Jonathan Bell studio
11 Sinclair Gardens
London W14 0AU

14 September 2020

CM/25/20/PL

bund planting plan
CM_BP01
Scale: 1:500 + 1:50
Date:16.06.2020

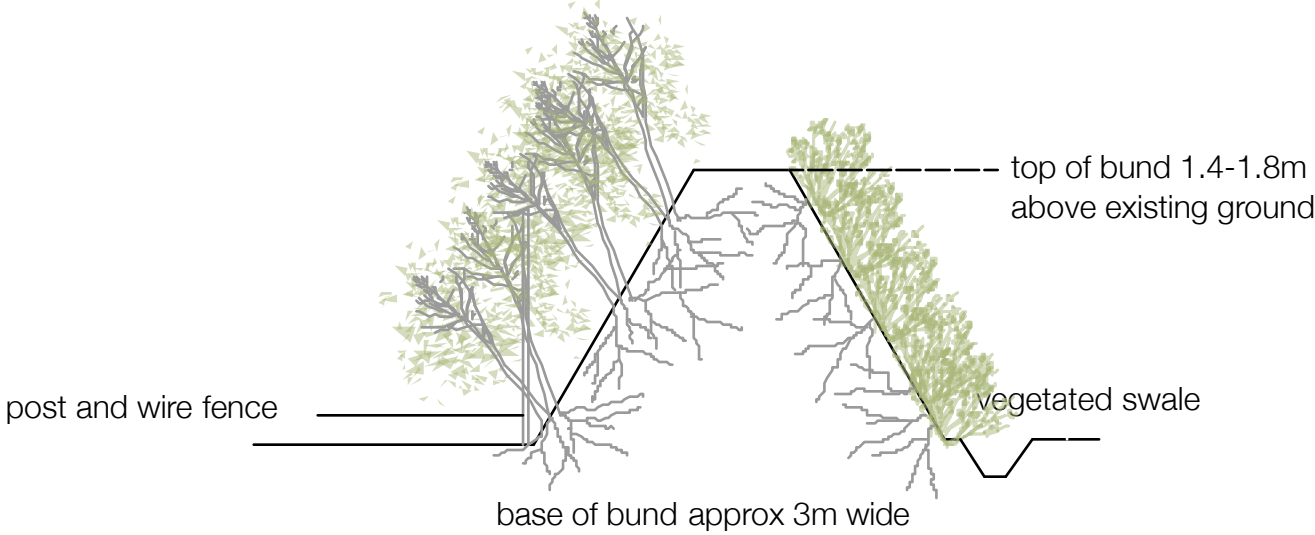
- Correlation on the size of the pond between pond planting and bund planting plan and deletion of reference to partially excavated pond (implying more excavation is to be done).

- Details of the bunds in cross section to establish that planting of vegetation will be successful in the long term. The fact that the bunds in many places are constructed on top of existing trees is not satisfactorily addressed.

I will amend the two drawings and issue them today.

The cross section on the Bund Planting Plan shows a typical bund detail and the Plant List describes species, size and spacings very clearly. These have already been planted and have been irrigated daily throughout the summer and have established well. As noted above, none of the pre-existing trees are protected so it is unclear why you feel you can demand that their protection is "satisfactorily addressed".
